## 88 Walker Street - BCA Pre DA Review Hotel Building

Report prepared for: Eastmark Holdings Pty Ltd  
C/o- Rice Daubney Architects  
100 Walker Street  
North Sydney  
NSW 2060

Report Ref: 09026Capstat\_20090408Hotel

Date: 07 April 2009

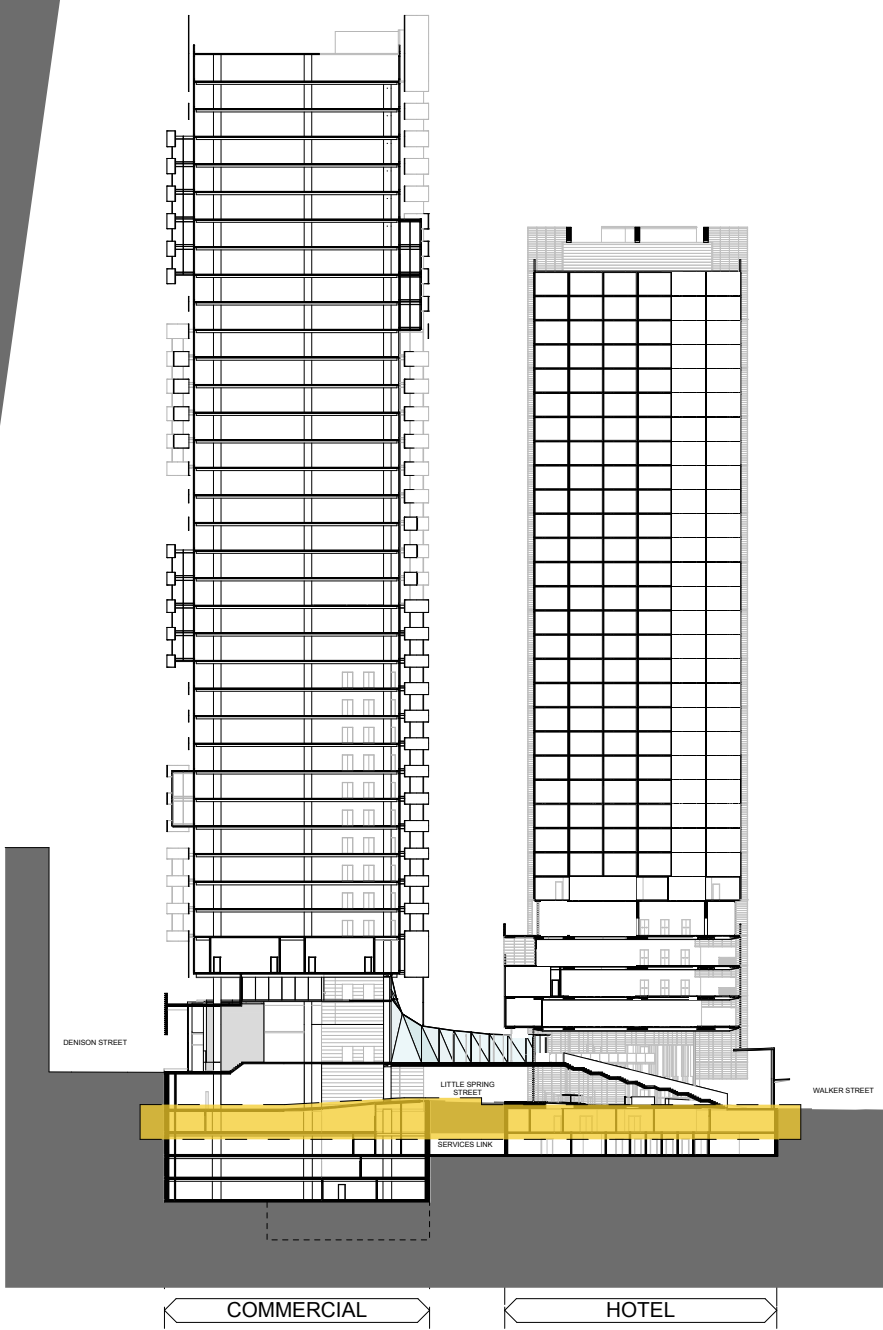
- A review of the paths of travel to basement 2 is required once the layouts are confirmed.
- The distance of travel to a point of choice on the residential hotel levels is greater than 6 metres
- The open stair from the conference level to the bar level connects three levels, however does not connect the ground, hence is not to BCA.
- An additional fire exit needs to be provided at the level with the bridge link.
